DRAINAGE INFORMATION SHEET

PROJECT TITLE: Eastridge, - phase II ZONE ATLAS/DRNG. FILE #: J-22/044
 LEGAL DESCRIPTION: Replat Tract B-2, Block 11, Eastridge Add., Unit #4
 CITY ADDRESS: 1560 San Jalo N.E.

REF: DRAINAGE PLAN FOR EASTRIDGE-PHASE II, RECEIVED APRIL 24, 1985 (J22-D44)

RE: DRAINAGE PLAN FOR EASTRIDGE PHASE II (J22/D44) RECEIVED APRIL
24, 1985

DRAINAGE / GRADING PLAN
EASTRIDGE - PHASE II

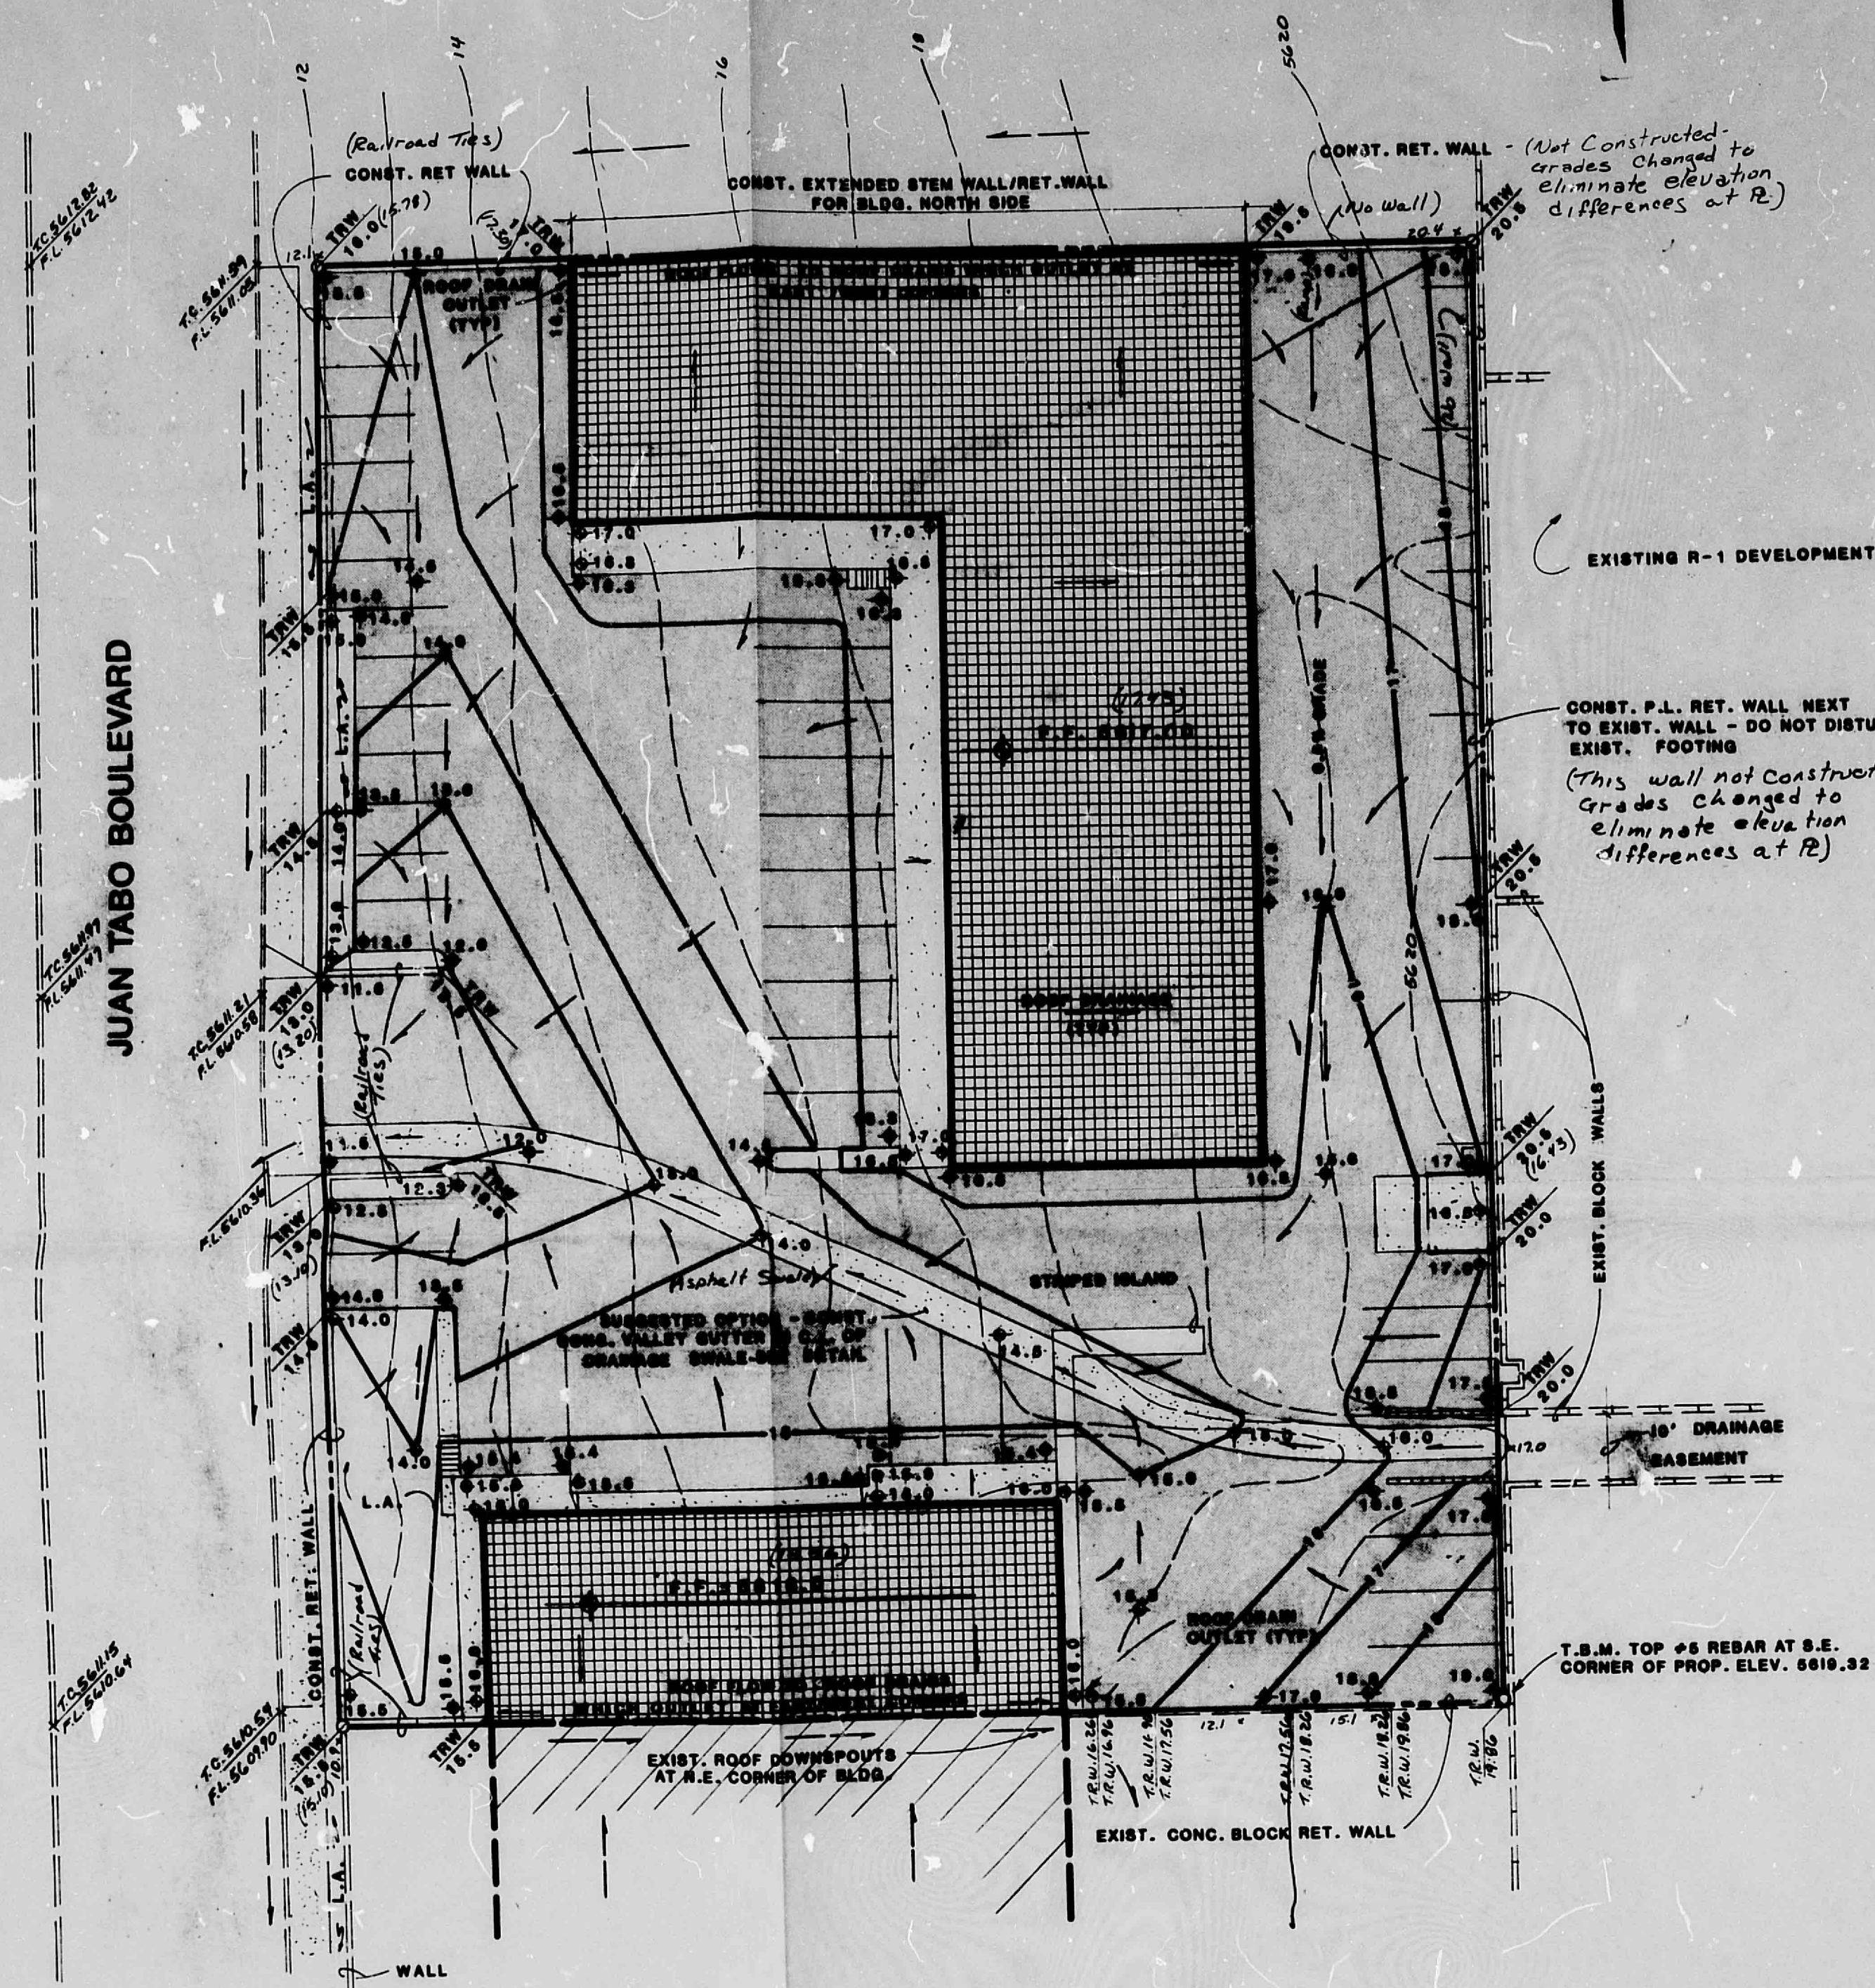
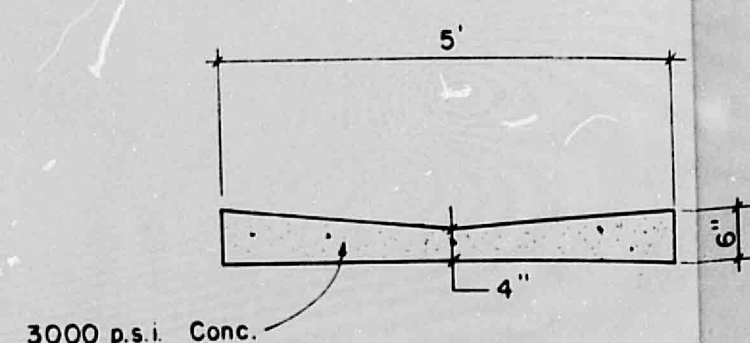
Further review of the drainage plan has shown the following items are not completed. Require an Encroachment Agreement for the drainage easement which crosses the site. Also, the concrete drainage swale should be incorporated into the construction in the easement. If another method of conveying the off-site flows is proposed, please use a "Drainage Facilities Within City Right-of-Way" document for City review.
